REF WA 10619 HH

The above extension which has already been built which makes a mockery of your Planning laws.

PROPOSED PLANS AND SECTION

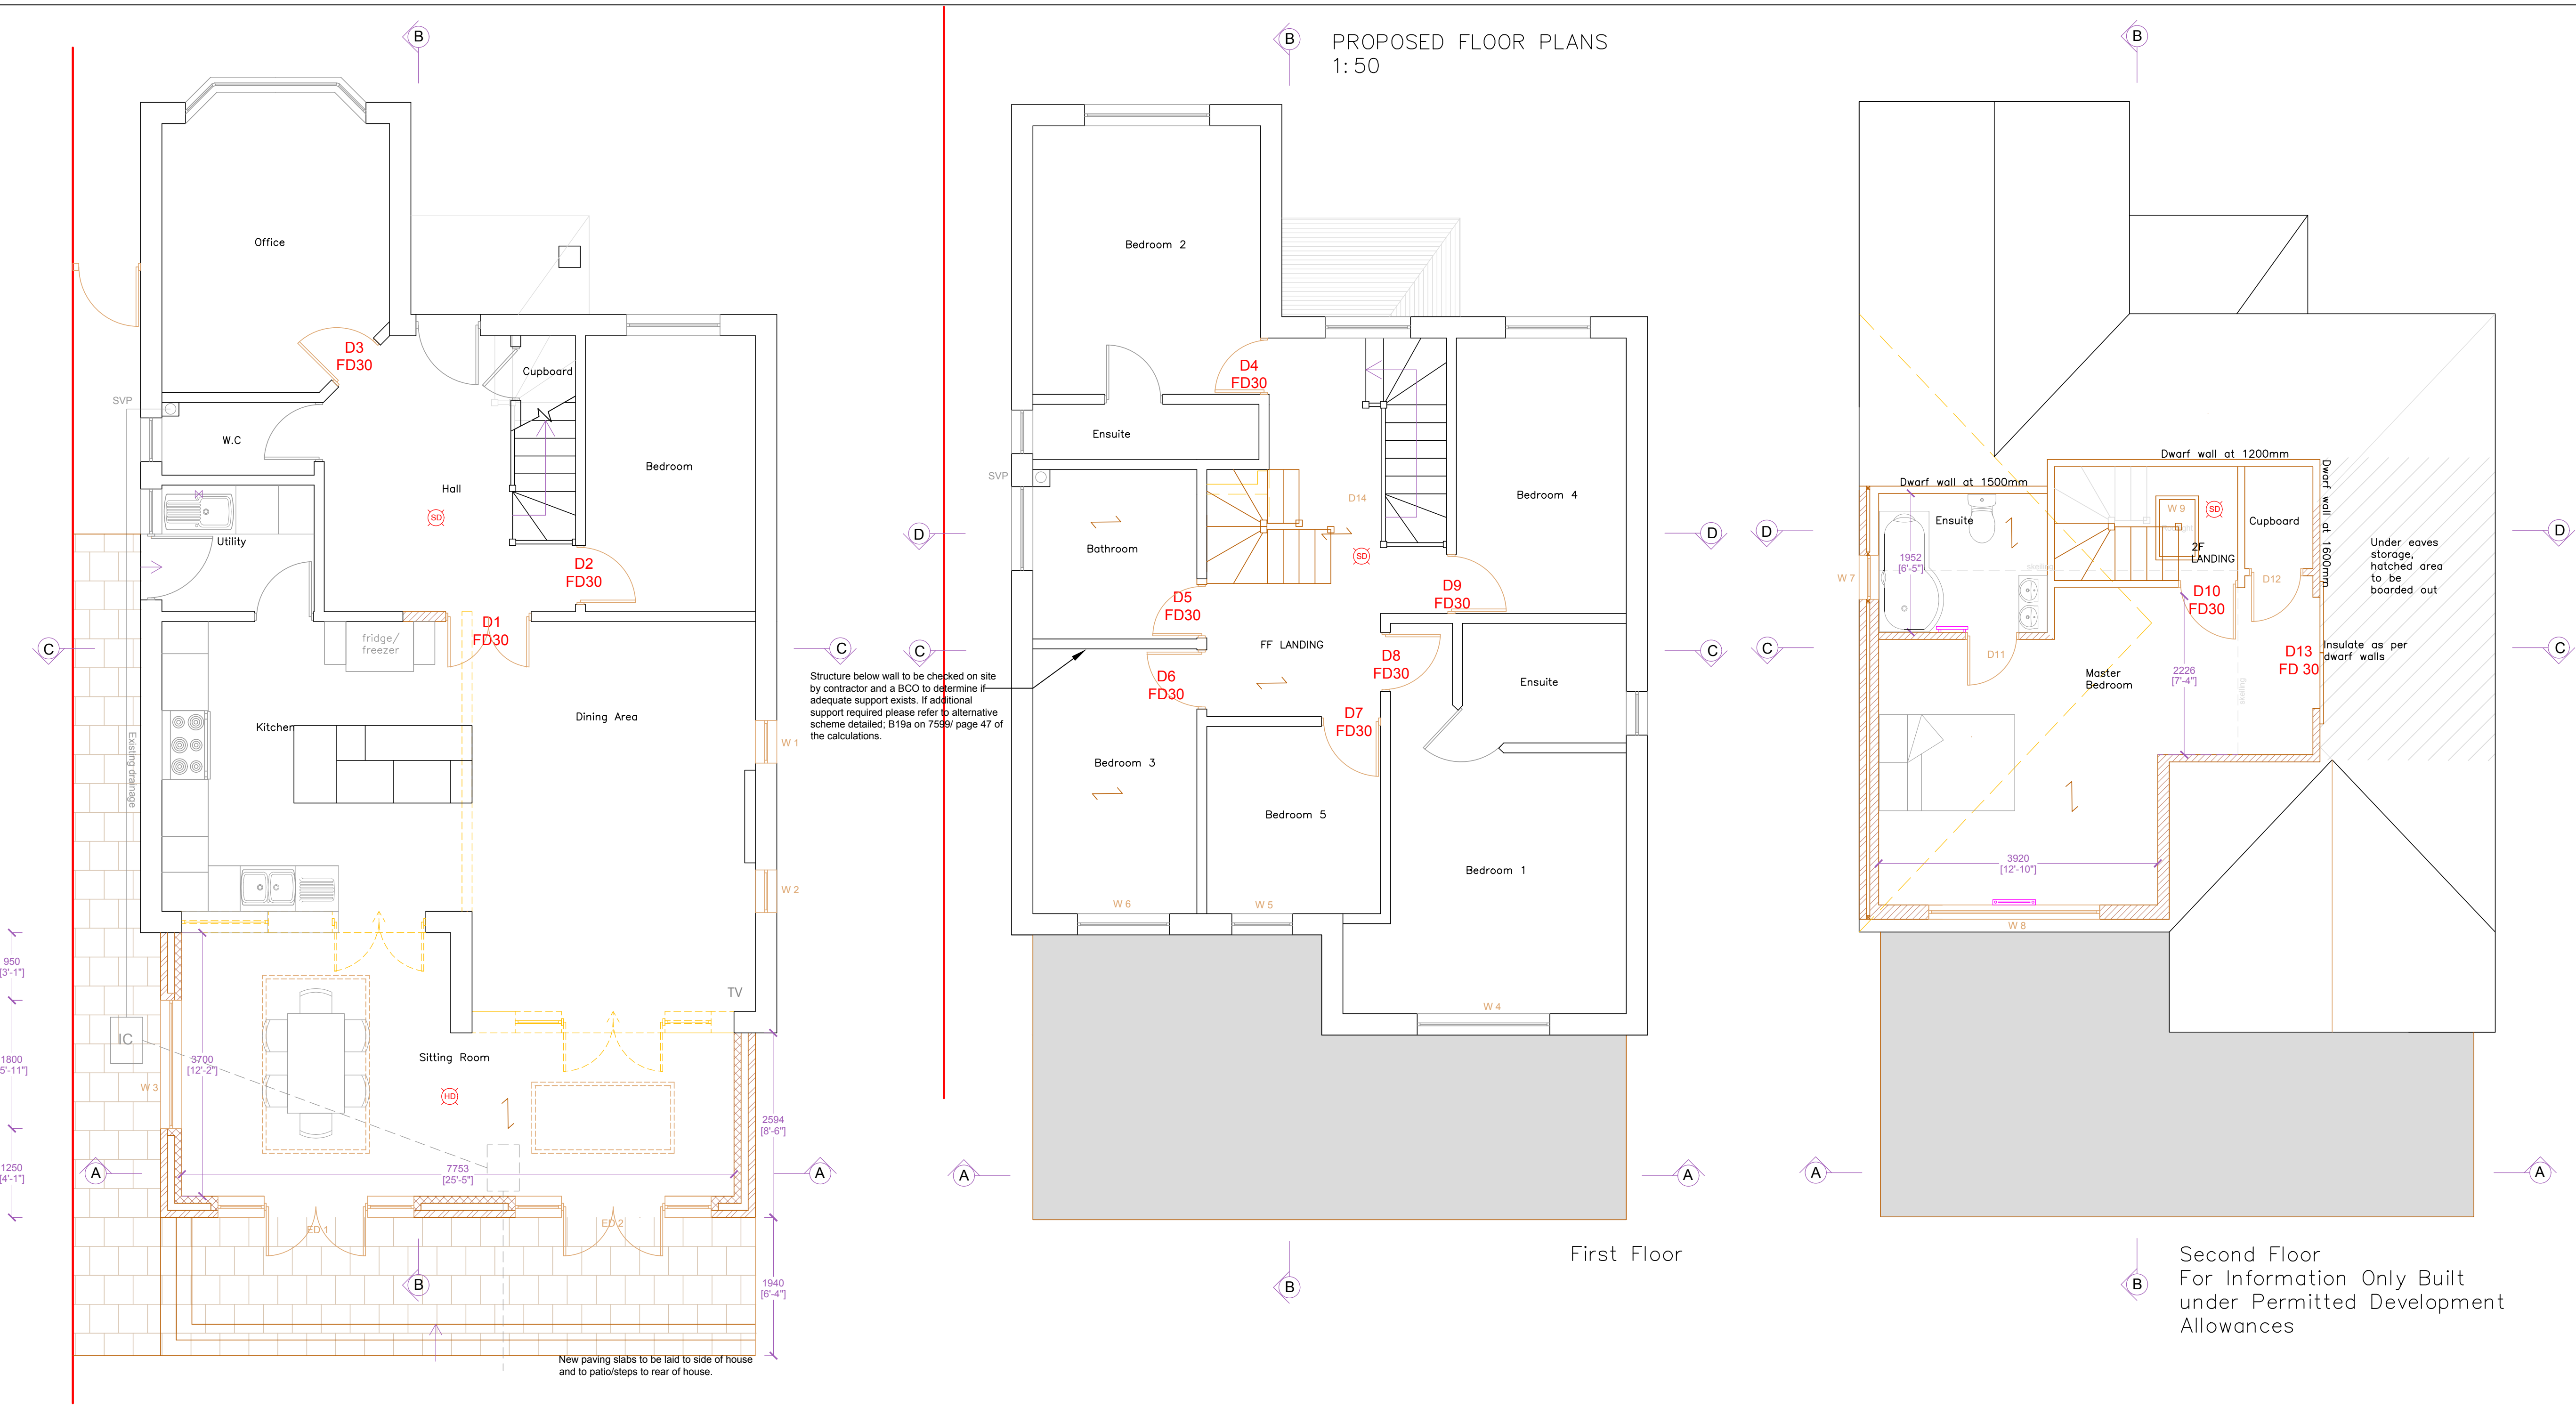
The windows and back door of this extension over look myself, neighbours + others gardens making it a Privacy issue, also the Dormer extension renders our gardens as not Private anymore.

The windows ~~are~~ are able to allow the occupants to gaze up into bedroom windows of several properties. So I know have to keep my bedroom Curtains permanently closed. The colour of the window frames do not match existing windows, making the property

This house has now become a three
storey property which is totally out of
keeping with the area.
